Planning Application Ref: AW/138/17/PL

Location : 90 Rose Green Road, Aldwick

Description of works: Demolition of existing dwelling & outbuilding & erection of 5 No dwellings.

Comments On Application:

Appendix 1: Tree Protection Plan

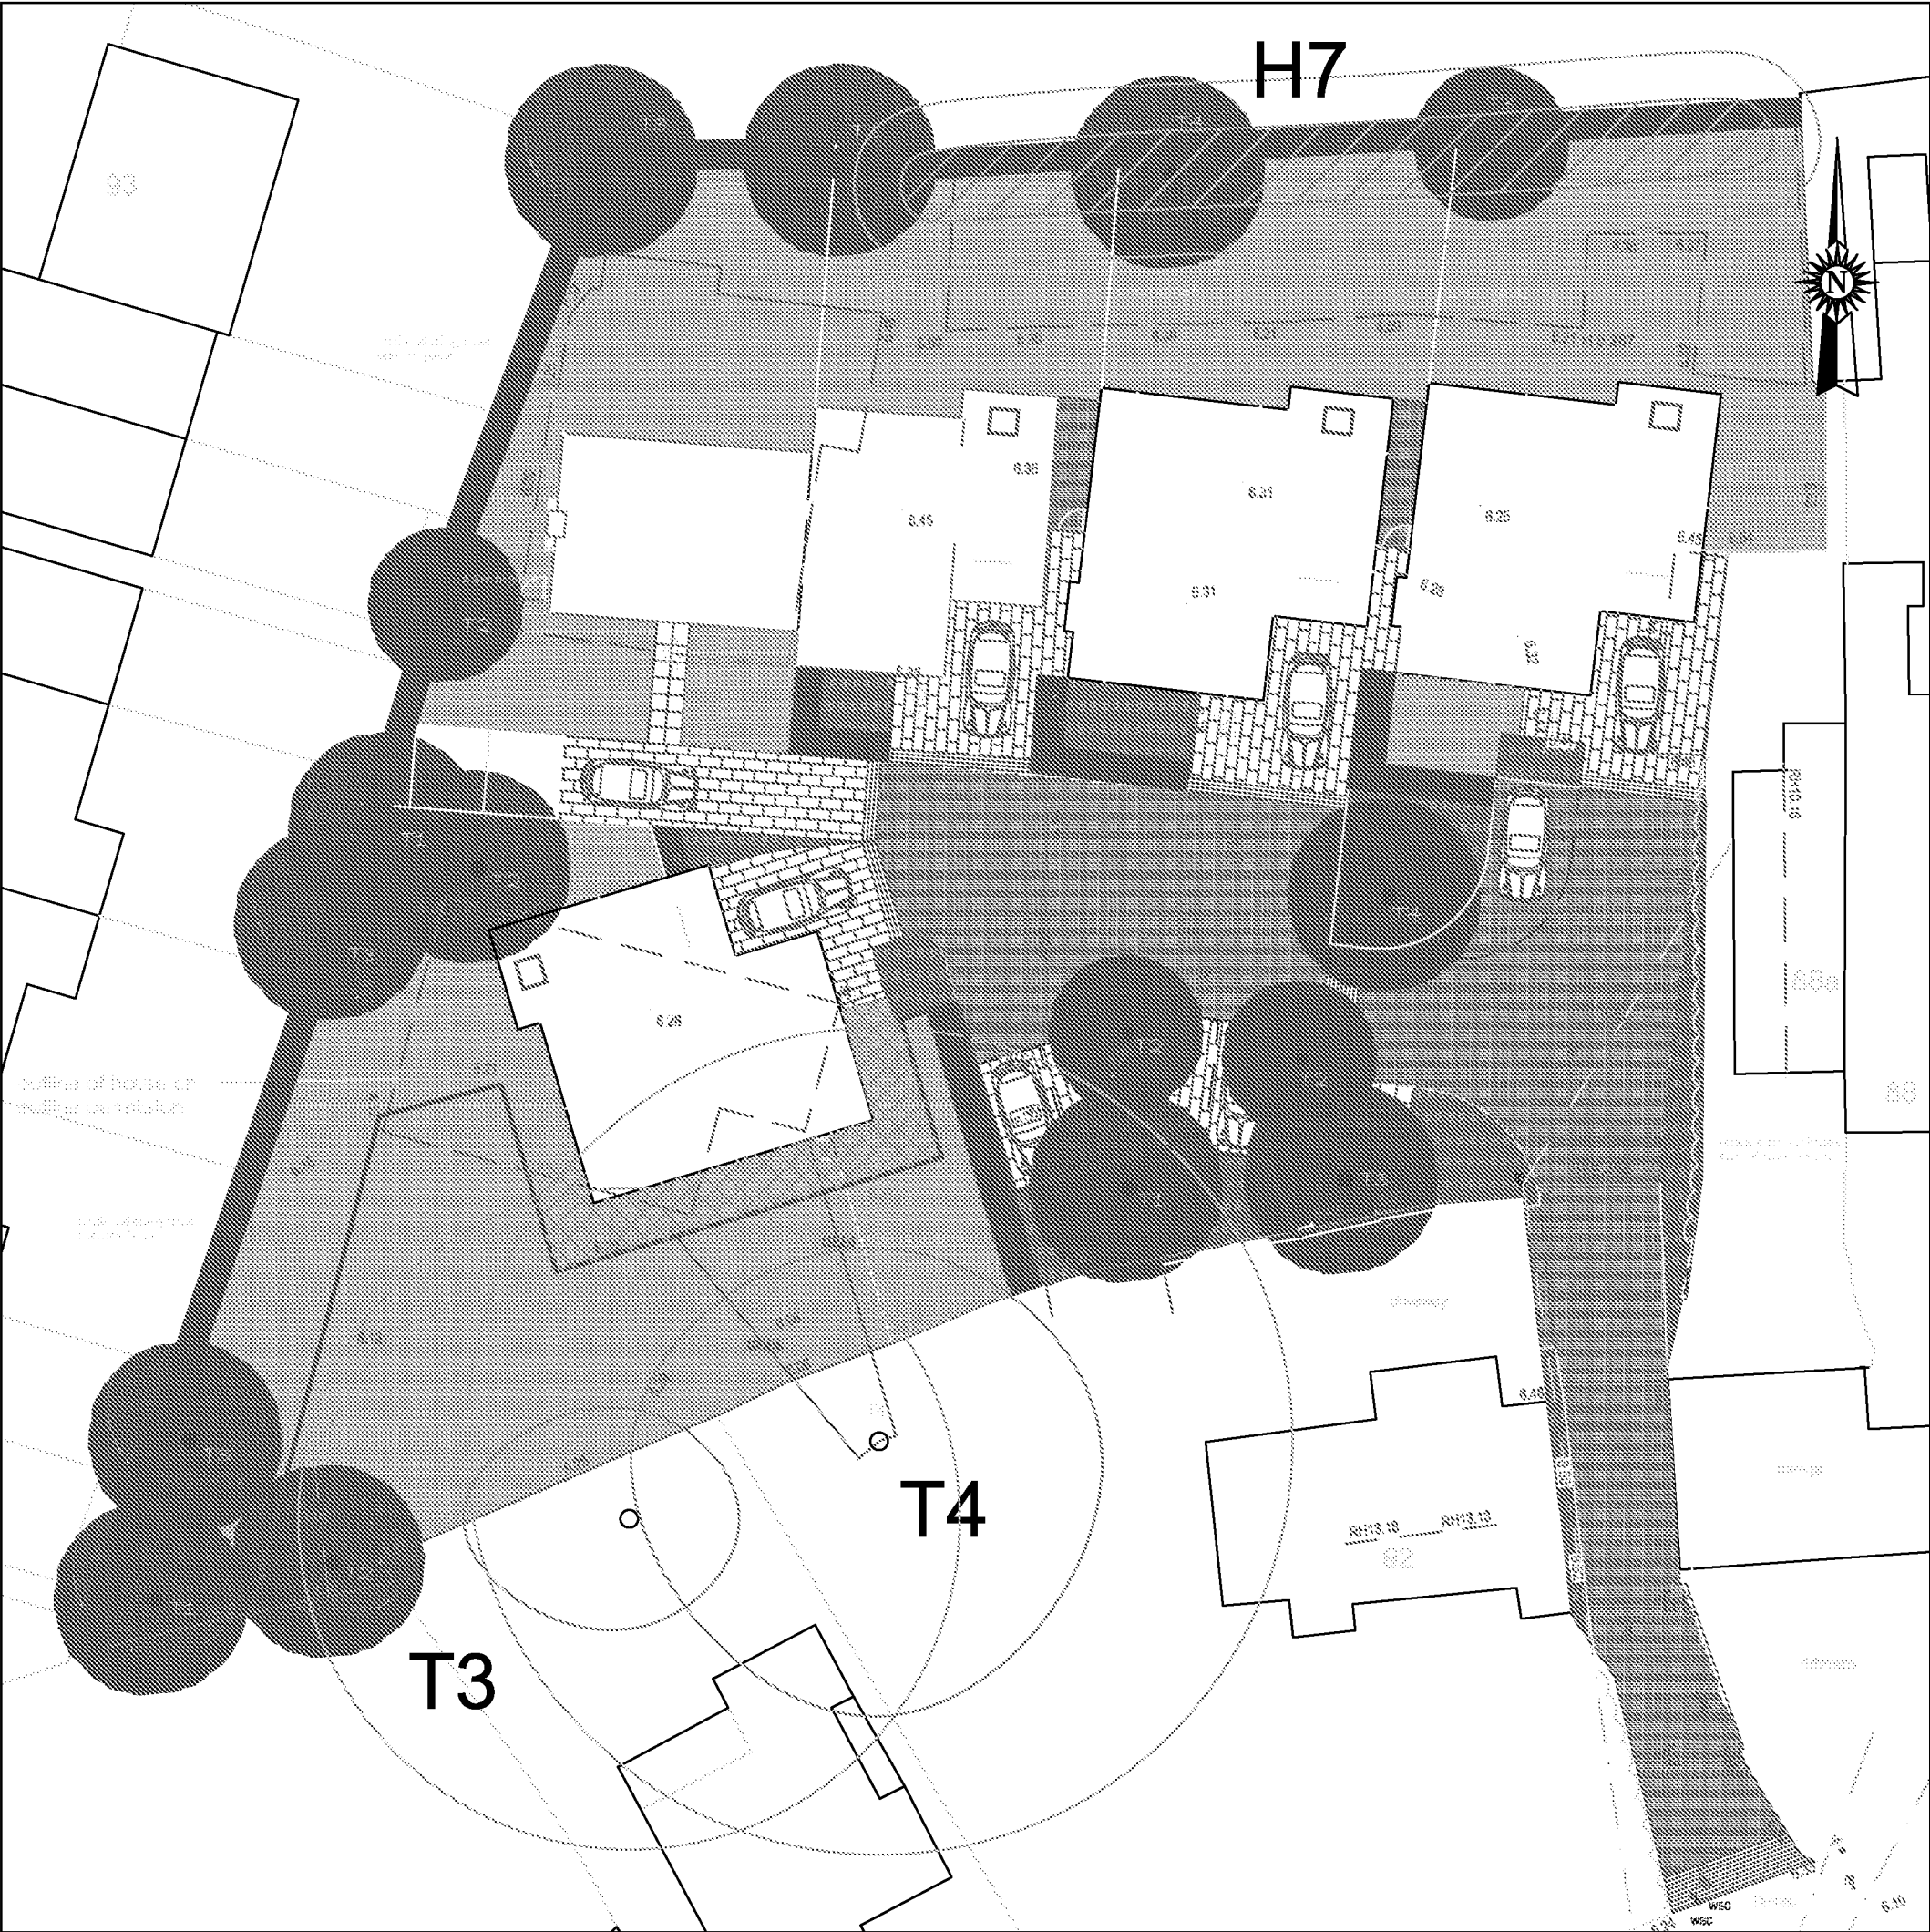
- The oak trees will need to be fully respected and protected during the demolition and construction phases of work.

- The following Conditions should be applied:-
- *All demolition & construction works are to be carried out in strict accordance with:- **RSK ADAS Arboricultural Planning Statement – May 2017 – PE/RH14 and Tree Protection Plan – TPP 01 Rev B 03.05.17.***

- *A **PRE-COMMENCEMENT Site Meeting** is to take place between the Arun DC Tree Officer and the Arboricultural Consultant representing the site owners – at this meeting all protective fencing will be inspected along with ground protection measures – they will be assessed to verify that they are 'Fit for Purpose' as required under British Standard 5837:2012 and have been erected and positioned exactly as shown on the **Tree Protection Plan – TPP 01 Rev B 03.05.17.***
